**Notification of Change to Proposed Development Subject to a
Planning Appeal**

Planning Appeal Reference: APP/C3105/W/23/3327213

Planning Application Reference: 22/02866/OUT

Land East of Ploughley Road, Ambrosden, OX25 2AD

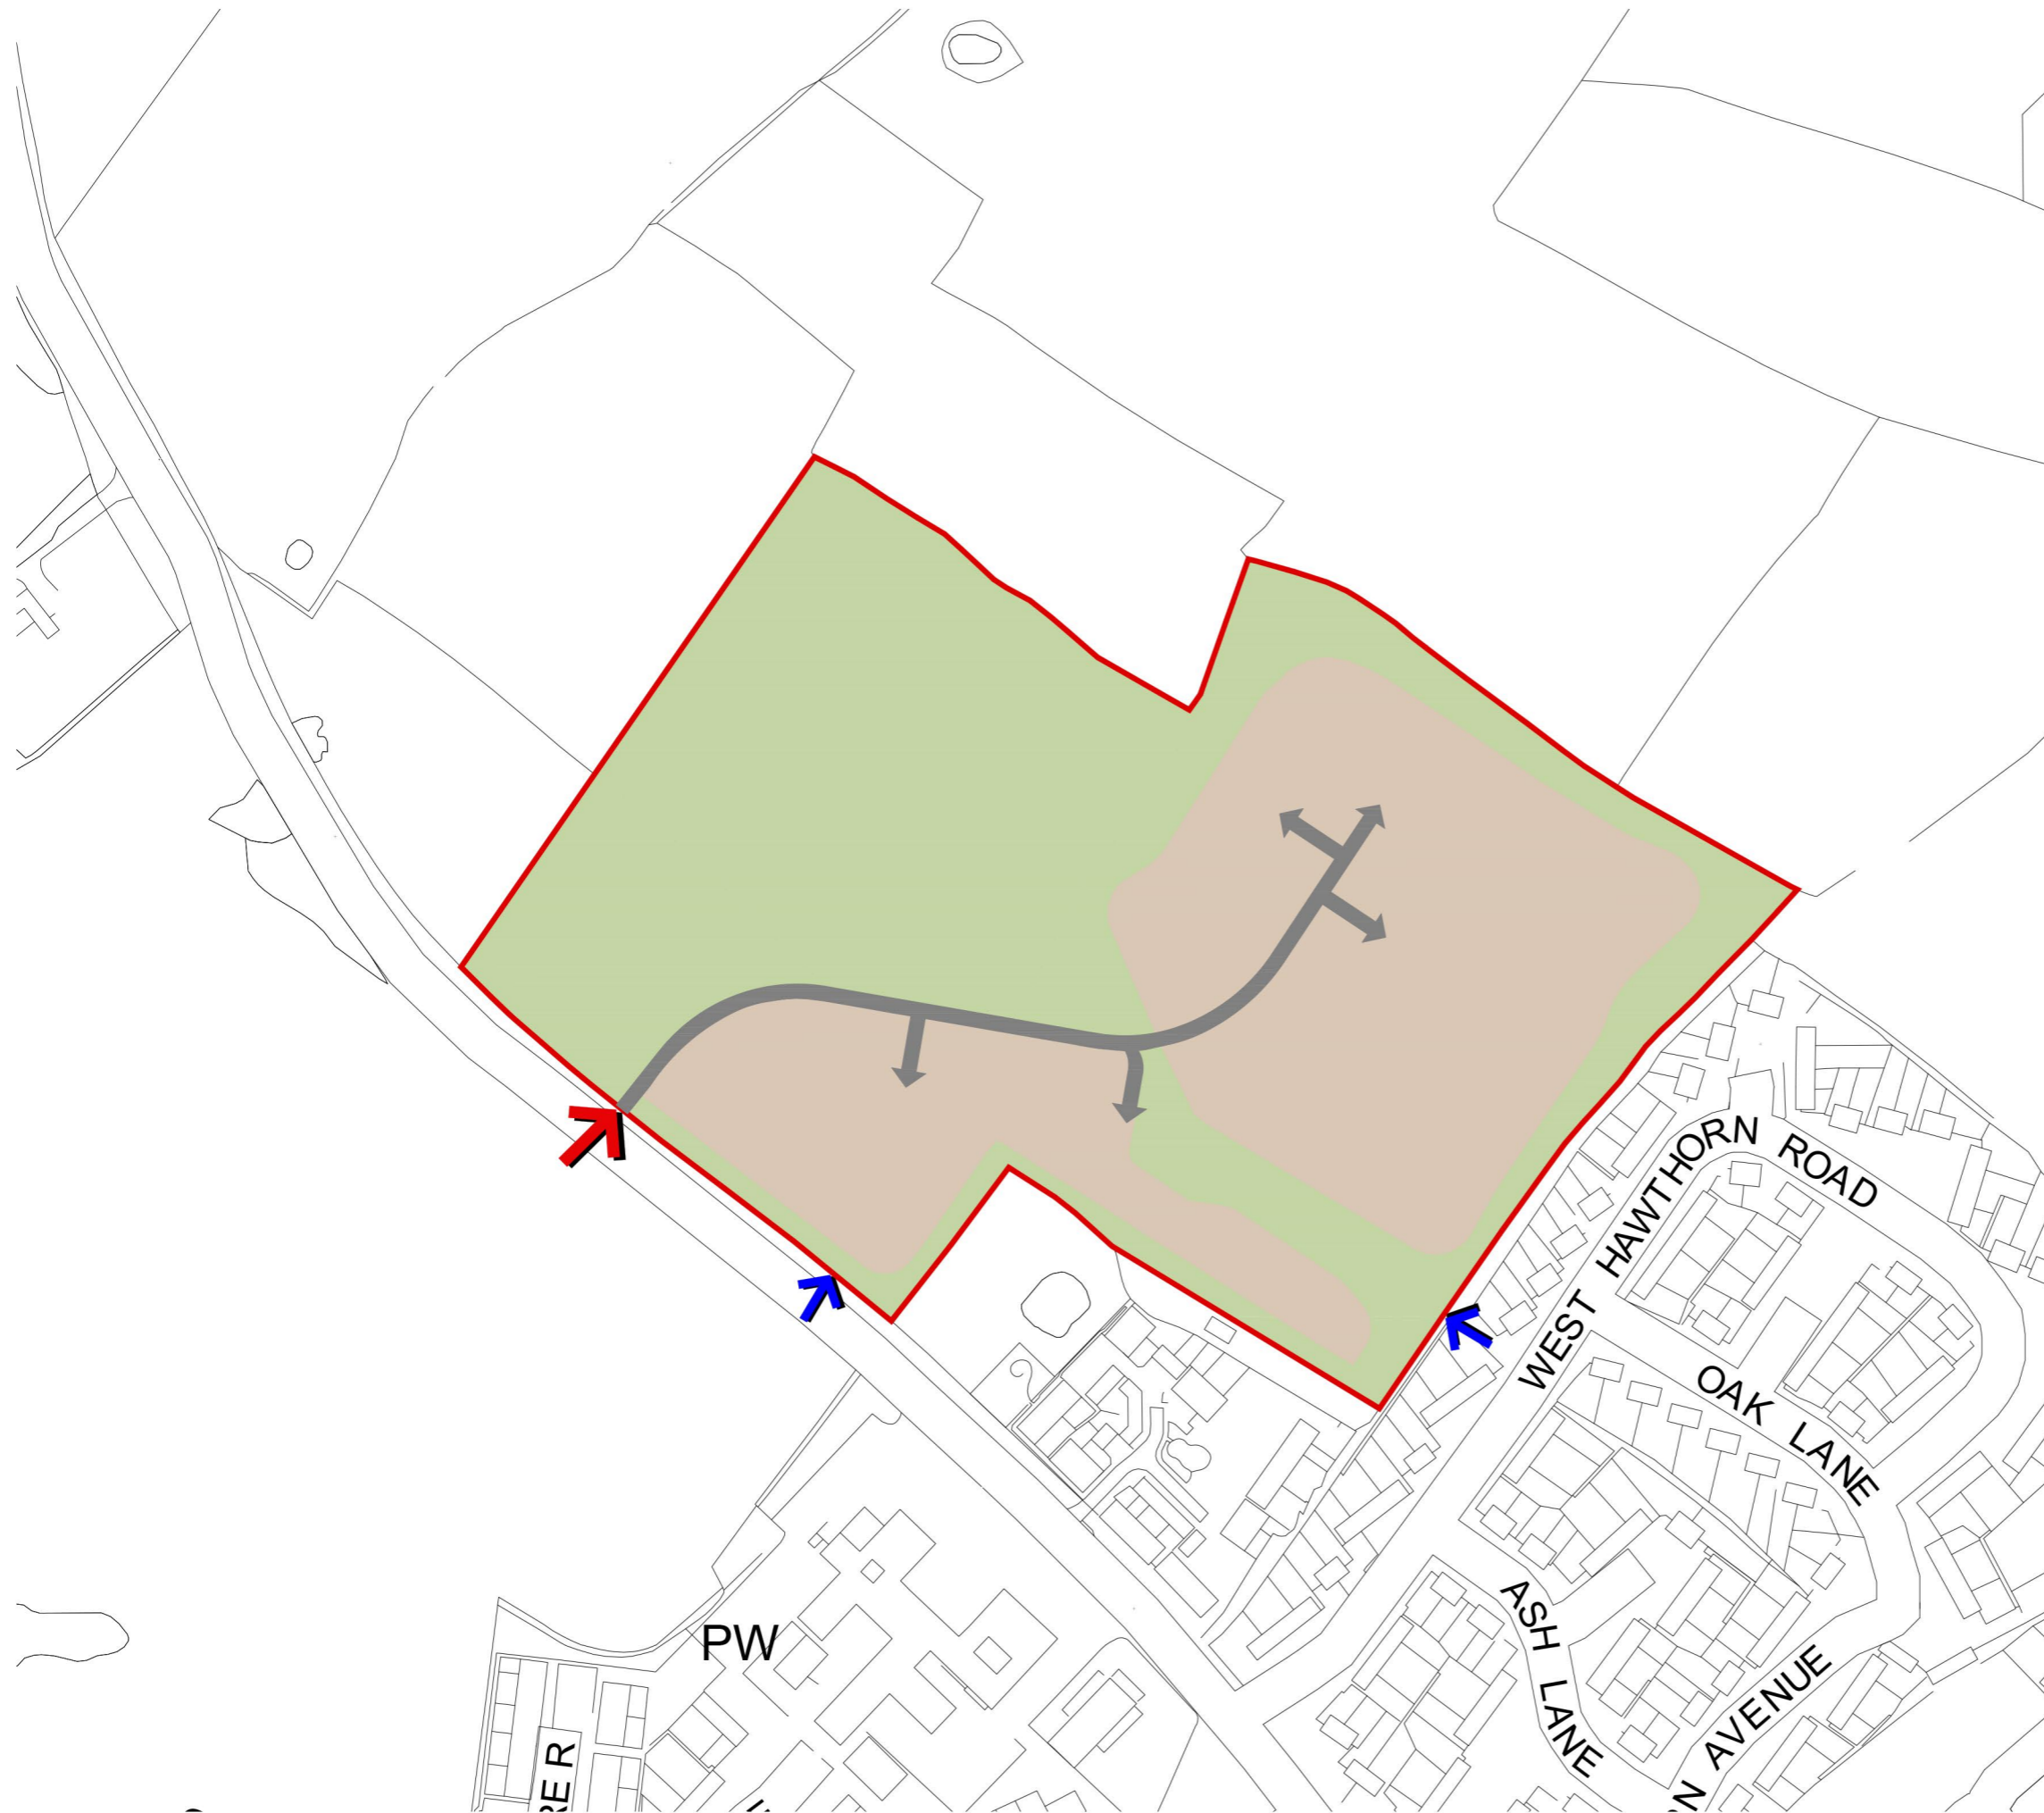
The proposed change is to omit reference to a new pedestrian access to West Hawthorn Road. The reason for this is to provide clarity that this is no longer the intention. A proposed pedestrian access to Ploughley Road will remain.

The proposed omission of a new pedestrian access to West Hawthorn Road has resulted in a change to the following 2 no. plans:

- Framework Plan, drawing number: FP-01 revision B (replacing previous version revision A)
- Parameter Plan Access, drawing number: 9603 revision B (replacing previous version revision A)
